Epping to Thornleigh Third Track Proposal. Application number SSI 5132.

Name(s): Andrew & Madeleine Grierson

I/we object to the Epping to Thornleigh Third Track Proposal and consider that the EIS is inadequate and does not address the full impact of this proposal. It will cause untold damage to the health of residents and to the fabric of the Beecroft Cheltenham Heritage Conservation Area. Do not approve this project, reconsider the alternatives and protect the community.

Figure S.6 Cross-section and elevation - New Cheltenham Station concourse building (see also S.5 for artist's impression)

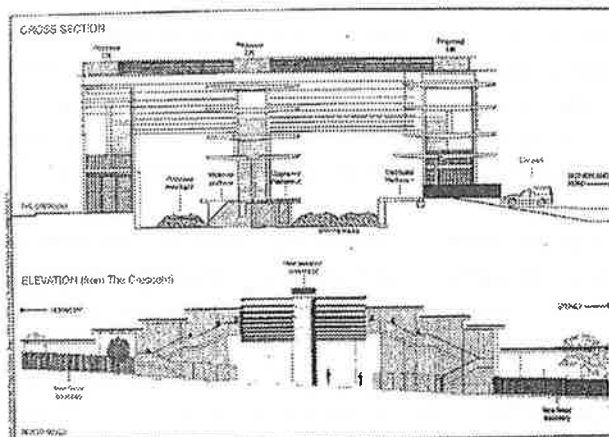
- The proposed redevelopment of Cheltenham Station shows no regard for the HCA. The visual impact of the proposed 13m high glass and steel concourse is totally unacceptable in this HCA.
